From: Gedney, David
Sent: 28 June 2011 09:17
To: Porter, Karen
Subject: FW: H18-0320-11 and H18-0321-11. Construction of Green Gateway visitor centre and change of use of garage to Sir Peter Scott museum, East Bank Lighthouse, Sutton Bridge
Attachments: Planning reply 27th june 2011.docx; Dwg 1 visitor centre plan view rev2.pdf; Dwg 2 elevations rev2.pdf

Subject: H18-0320-11 and H18-0321-11. Construction of Green Gateway visitor centre and change of use of garage to Sir Peter Scott museum, East Bank Lighthouse, Sutton Bridge

As previously discussed, it is our opinion that a number of minor revisions are required to make the applications more acceptable.

Drawing 9/1h/ 12/6/2011

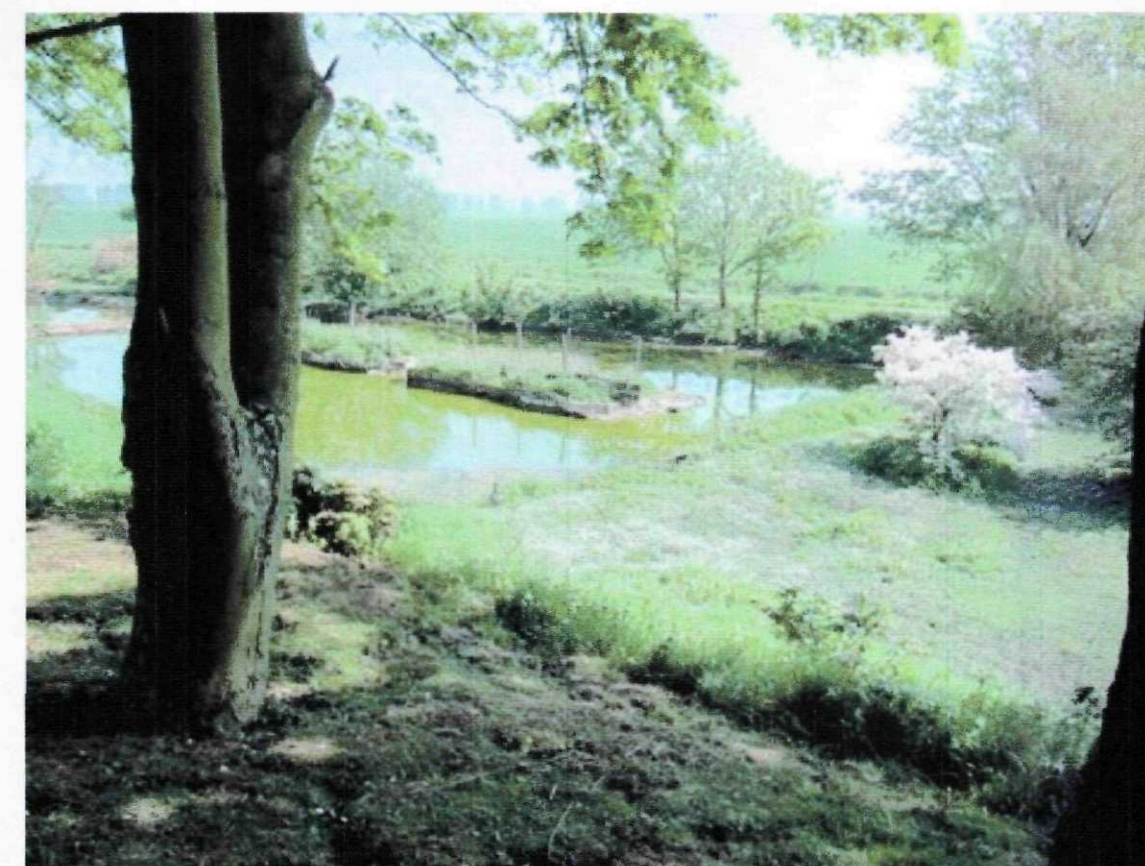
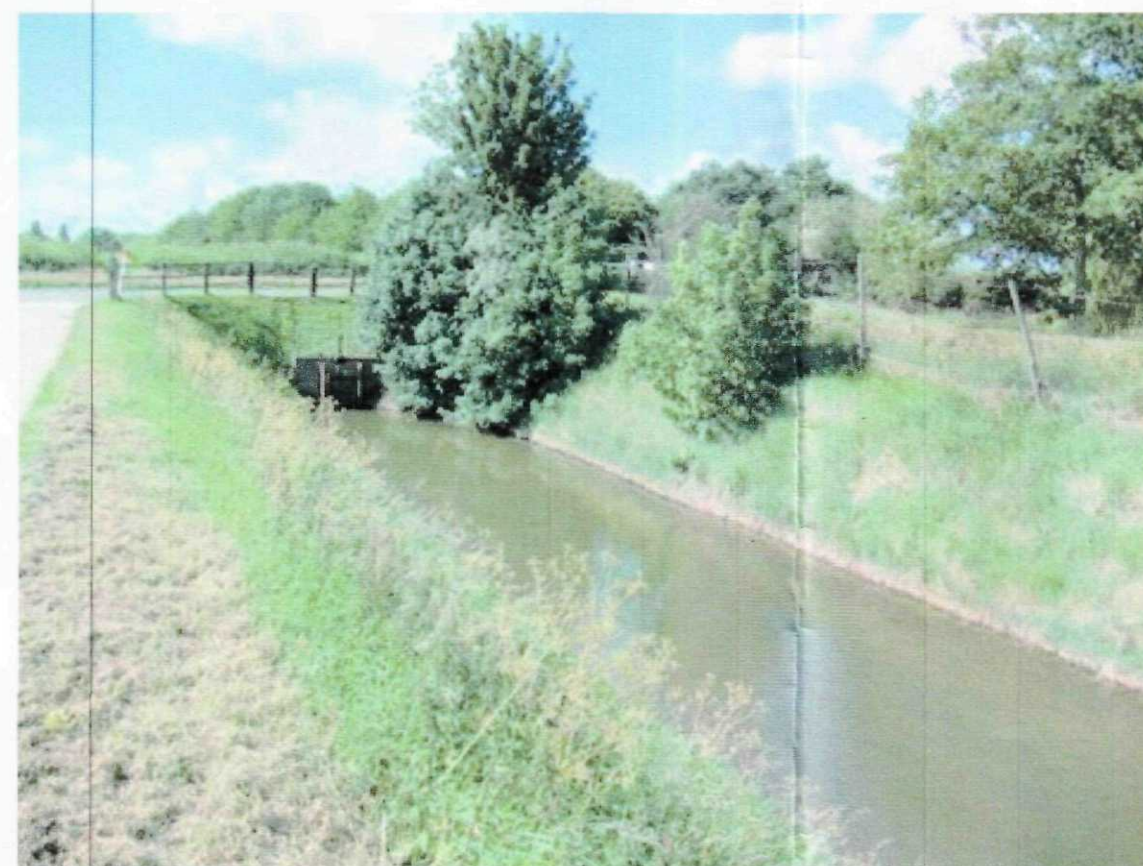
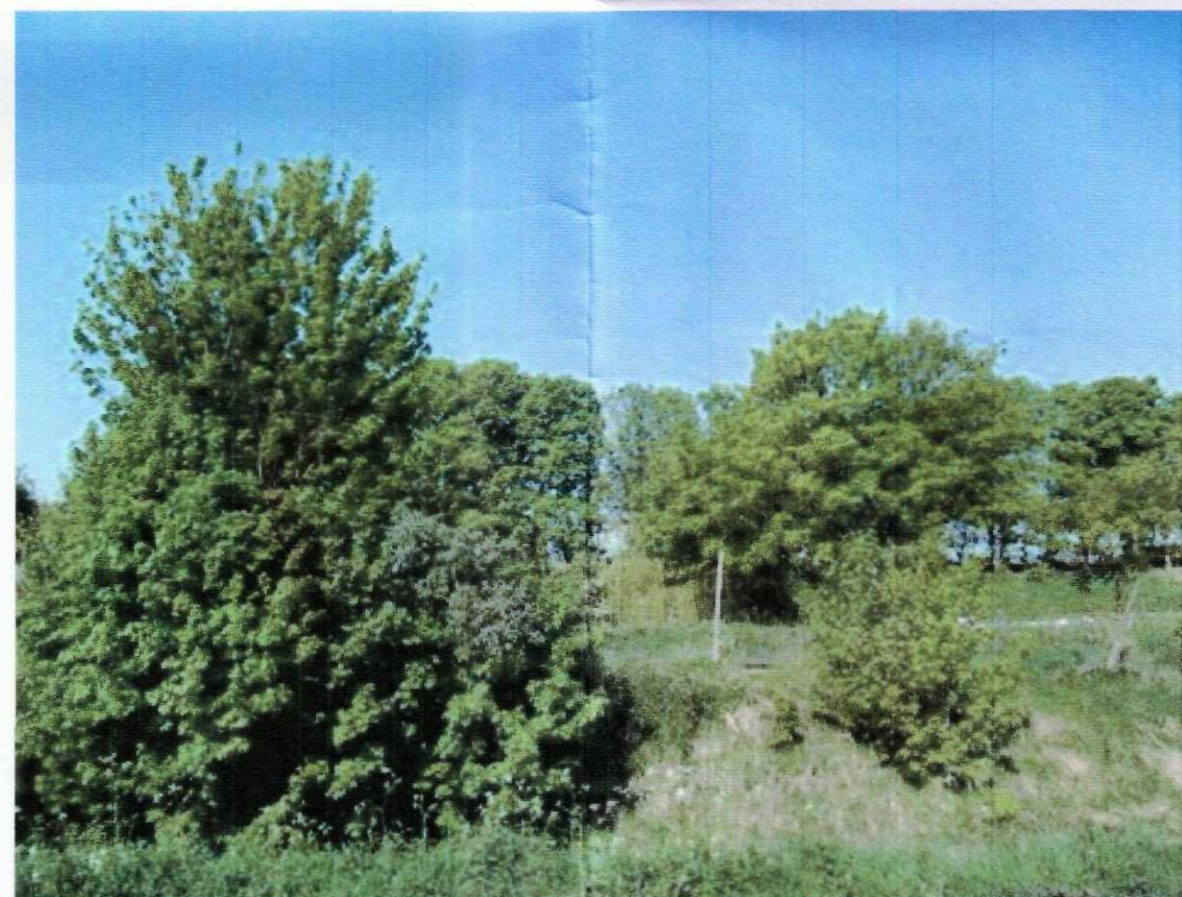
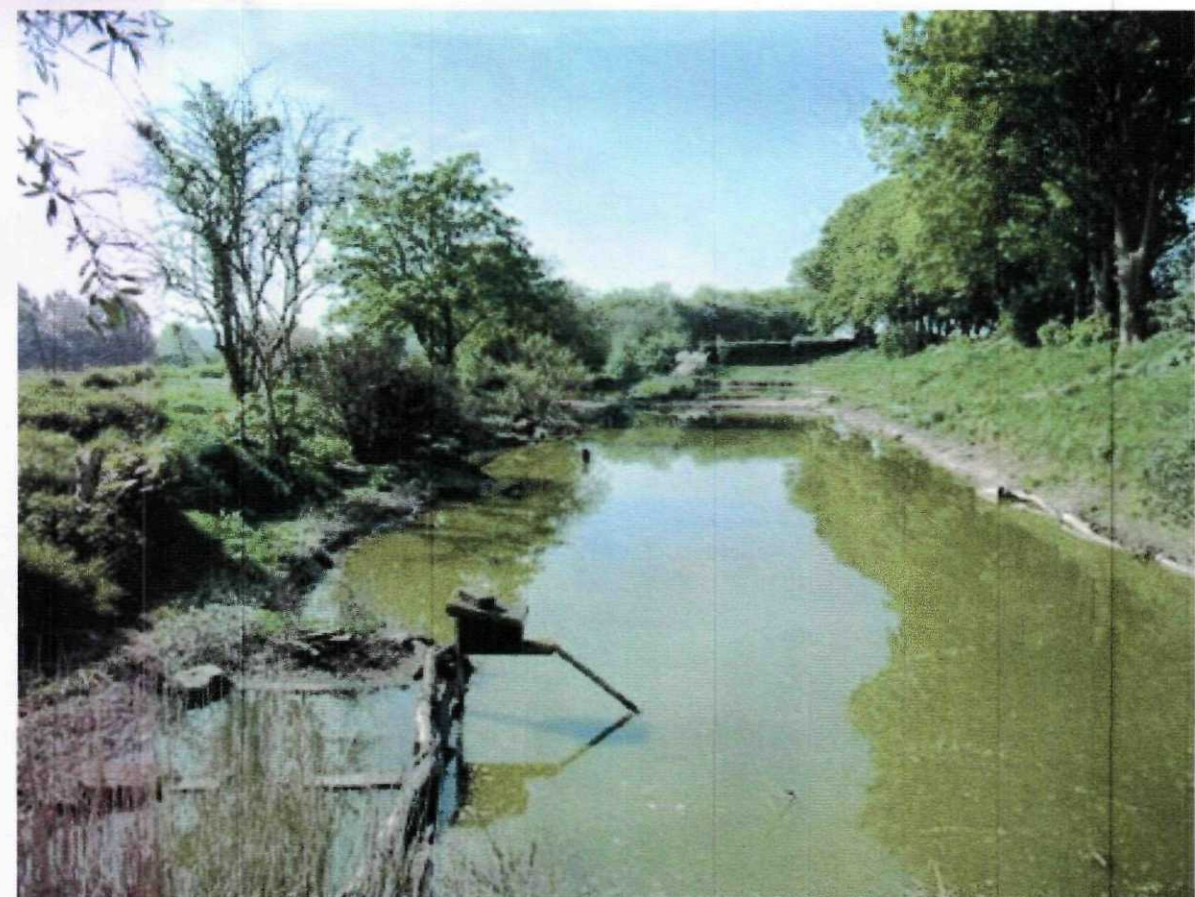
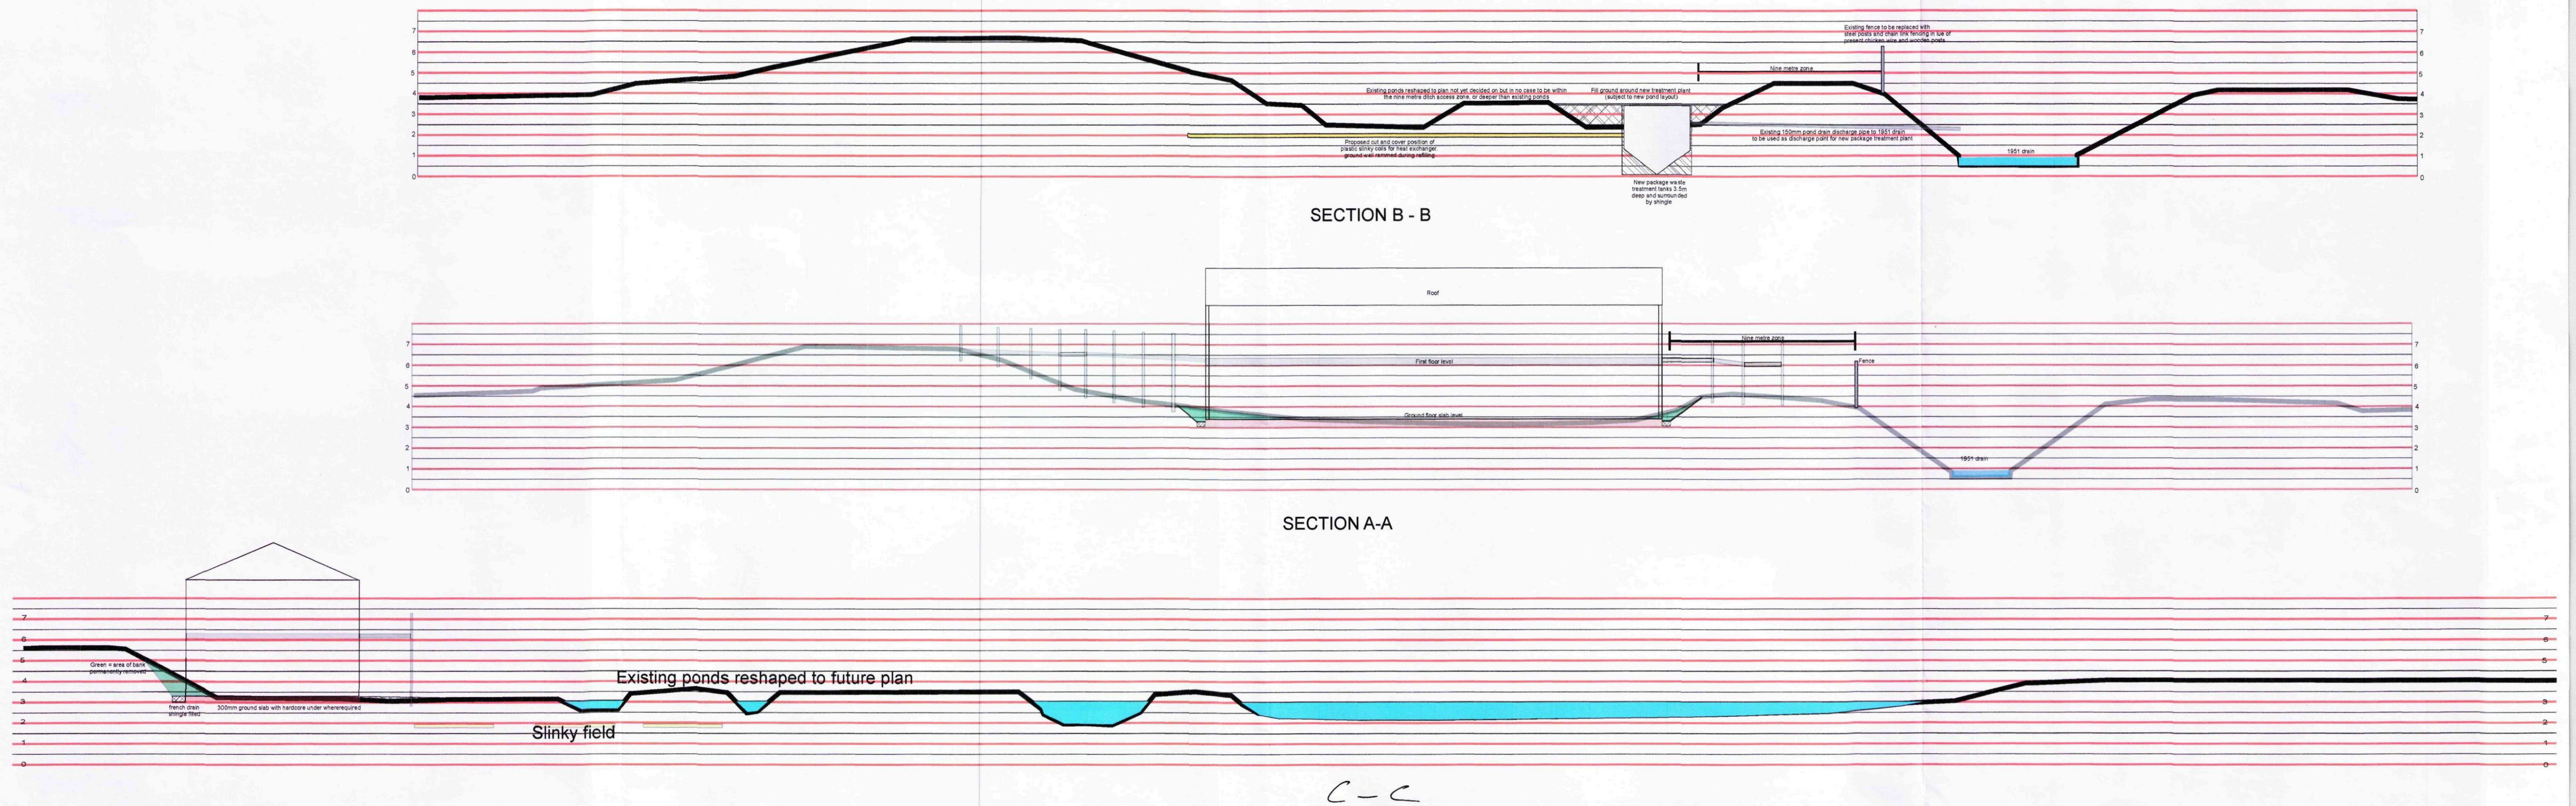
Lastly, I understand that we are still awaiting 2 hard copies of a drawing to a scale not exceeding 1:50 showing both the existing and proposed layouts and elevations of the garage, including details of the proposed external and internal alterations.

Sir Peter Scott Centenary Centre
East Bank Lighthouse, Sutton Bridge
Elevations
Drawing 21lh/11 - REV2
SCALE 1:100
AMENDED PLAN
Ref. A2
22/4/2011

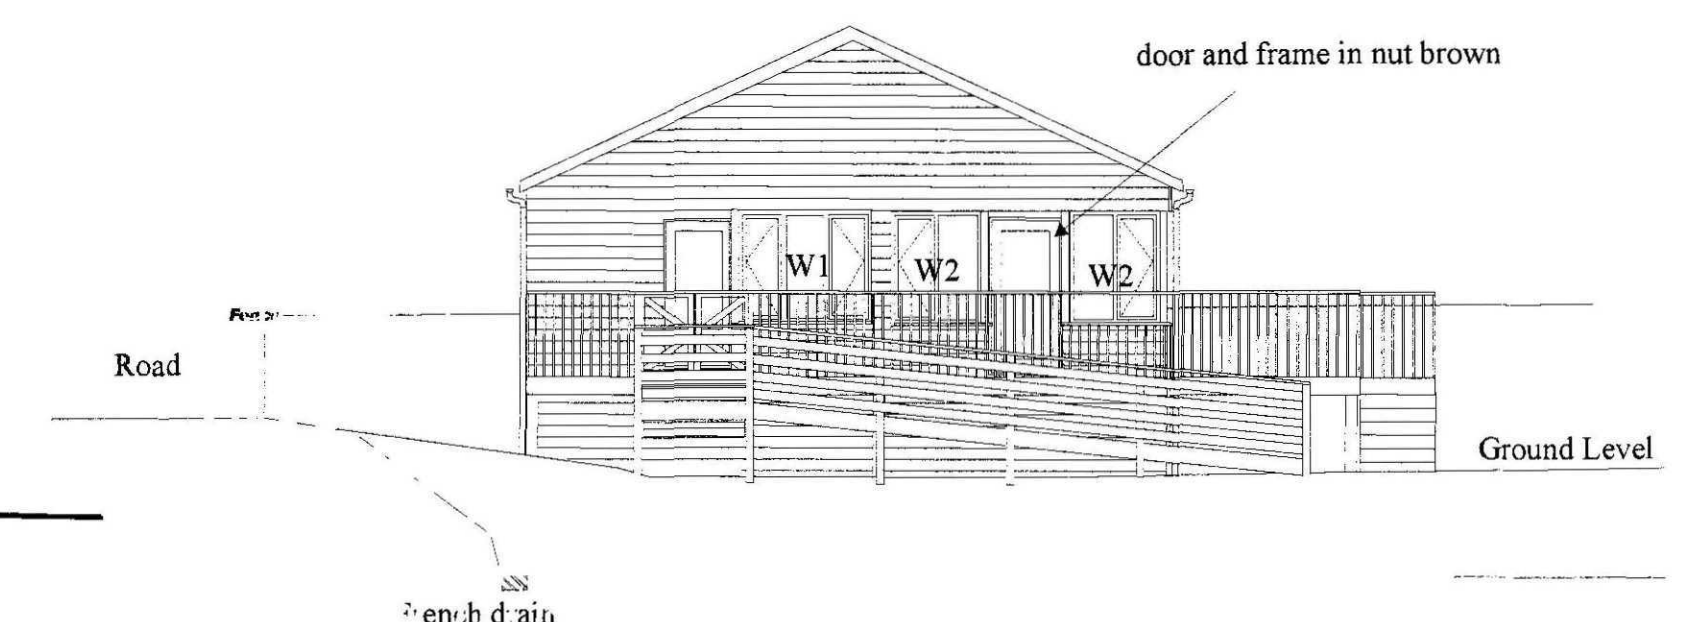
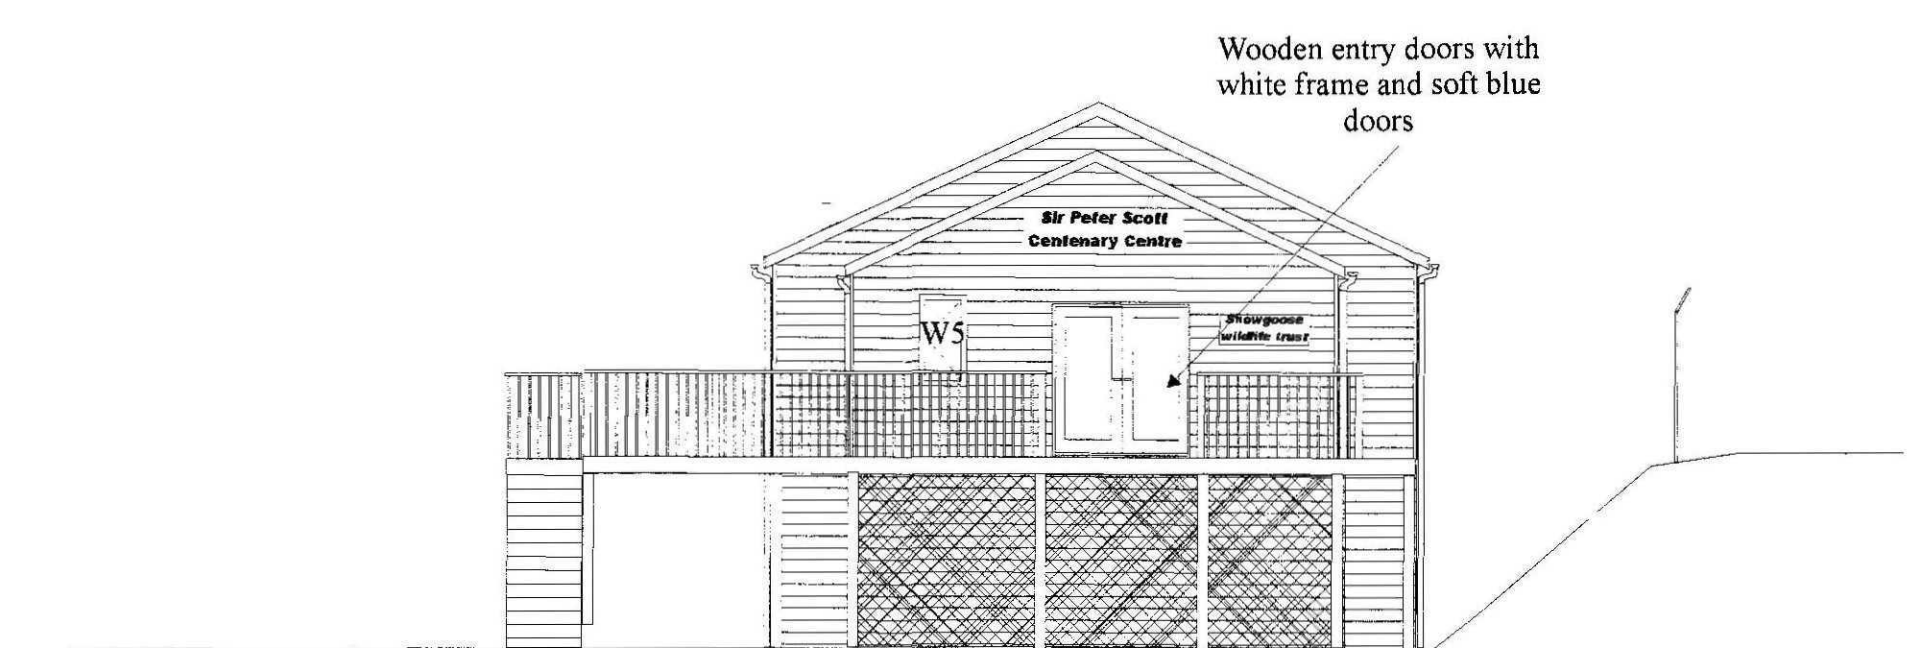
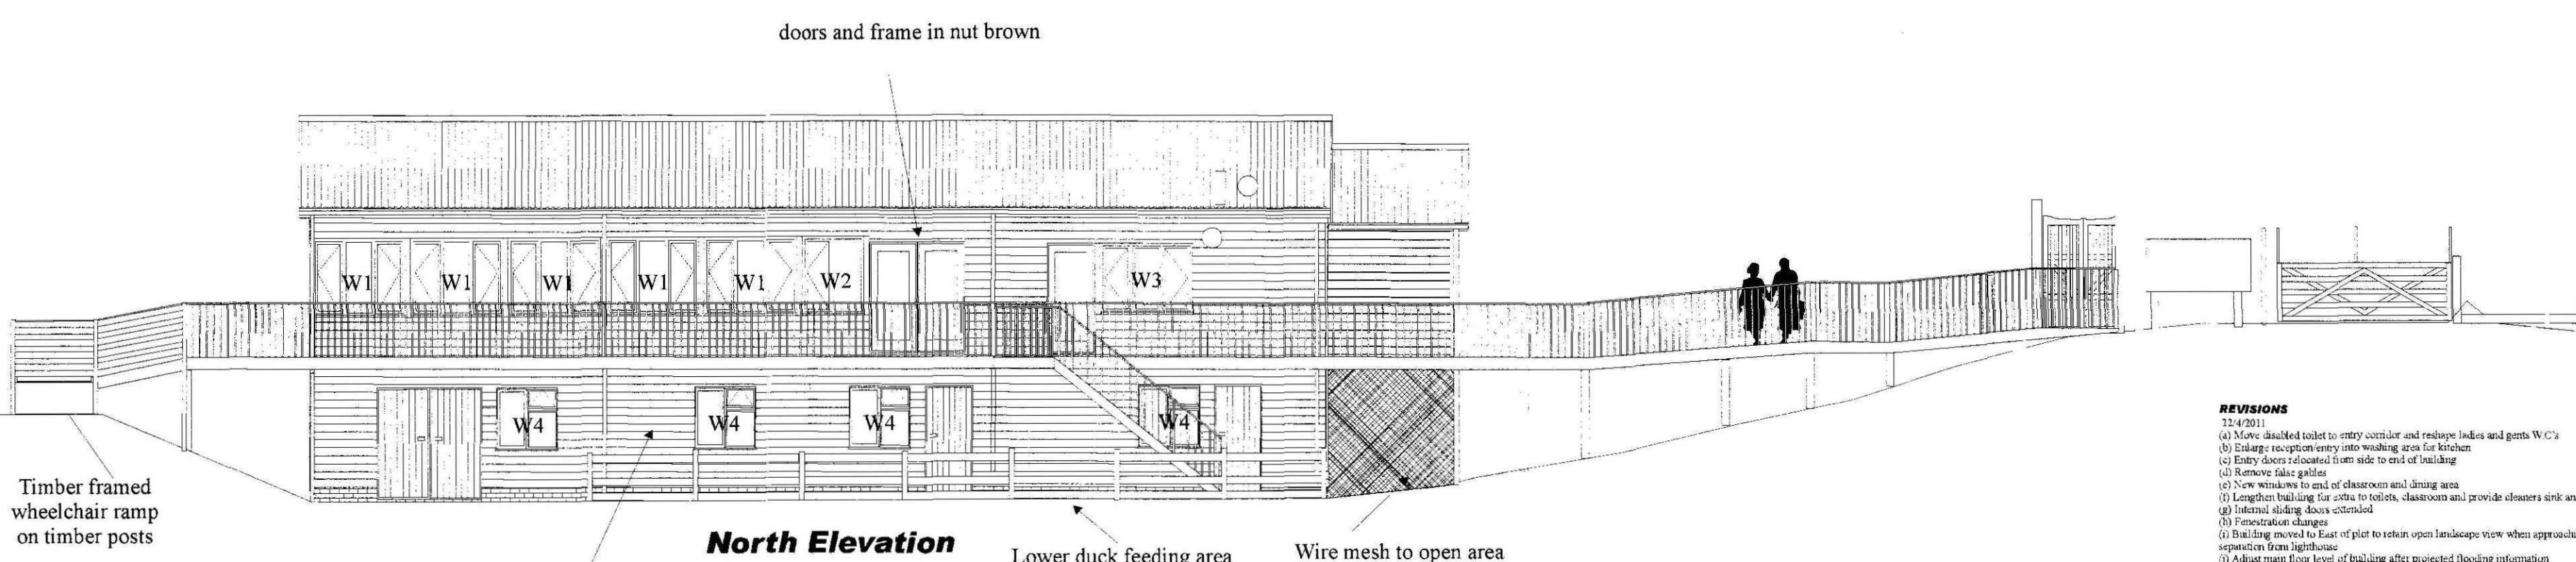
From a design point of view, it is considered that the new building should be a modern interpretation of a traditional marine building such as a boathouse. To achieve this, the fenestration should be revised and constructed in either aluminium or timber.

The windows on the southern elevation should be small and square (approx 500mm x 500mm) with four panes of equal size. In respect of the northern and eastern elevations, it is assumed that clear views are required of the lighthouse, lakes, etc. To achieve this, a continuous row of windows could be utilised, as indicated on the attached sketch. This would fulfil a functional need and also give the building an individual quality.
